DESIGN INTEGRITY PANEL ENDORSEMENT - 8-10 LEE STREET, HAYMARKET [SSD - 10405]

This letter has been prepared on behalf of the Design Integrity Panel (formerly the Design Jury) for the 8-10 Lee Street, Haymarket Architectural Design Competition in relation to the design integrity process. It provides endorsement of the design by the Design Integrity Panel (DIP) prior to the lodgement of the SSD DA.

DRAWING
SHED - SOUTHERN
ELEVATION
DOCUMENT NUMBER
DA-11C-GXX-02
ISSUE
6

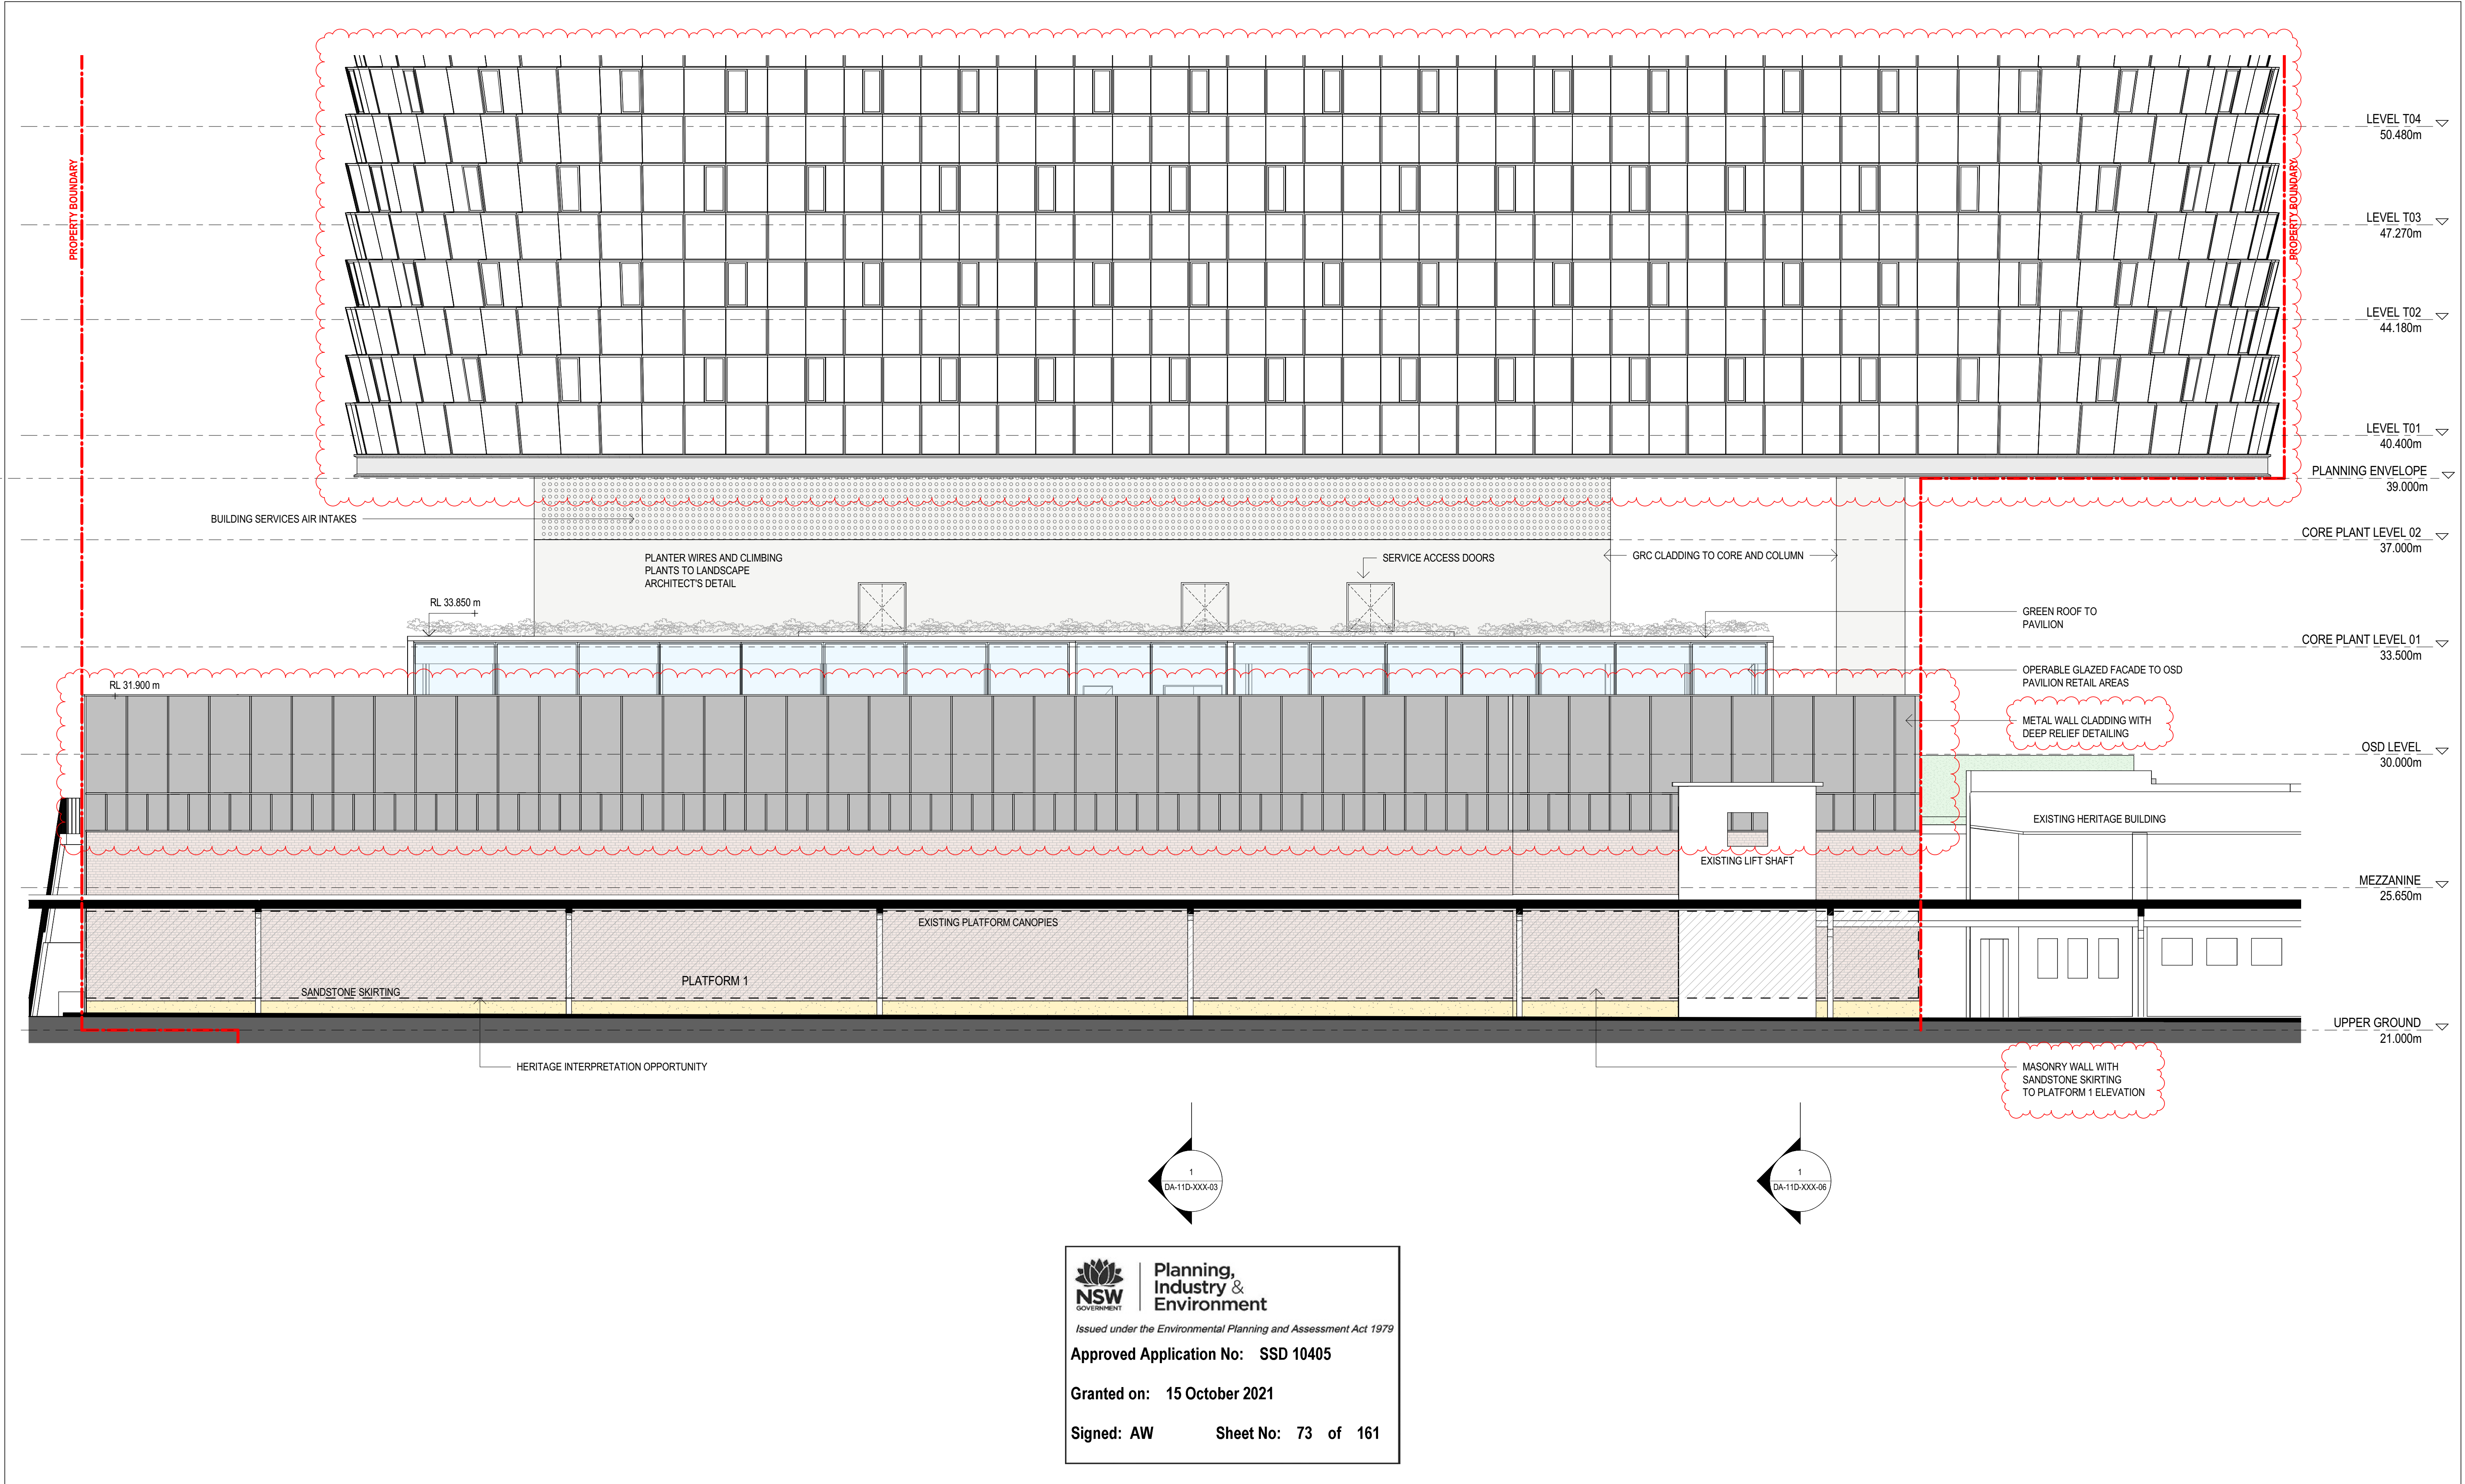
- **External Staircase** -Need to further consider the resolution of the external staircase located on the southern elevation of the shed, particularly if it is to remain as a more permanent structure, due to the potential visual impact on the readability of the shed.
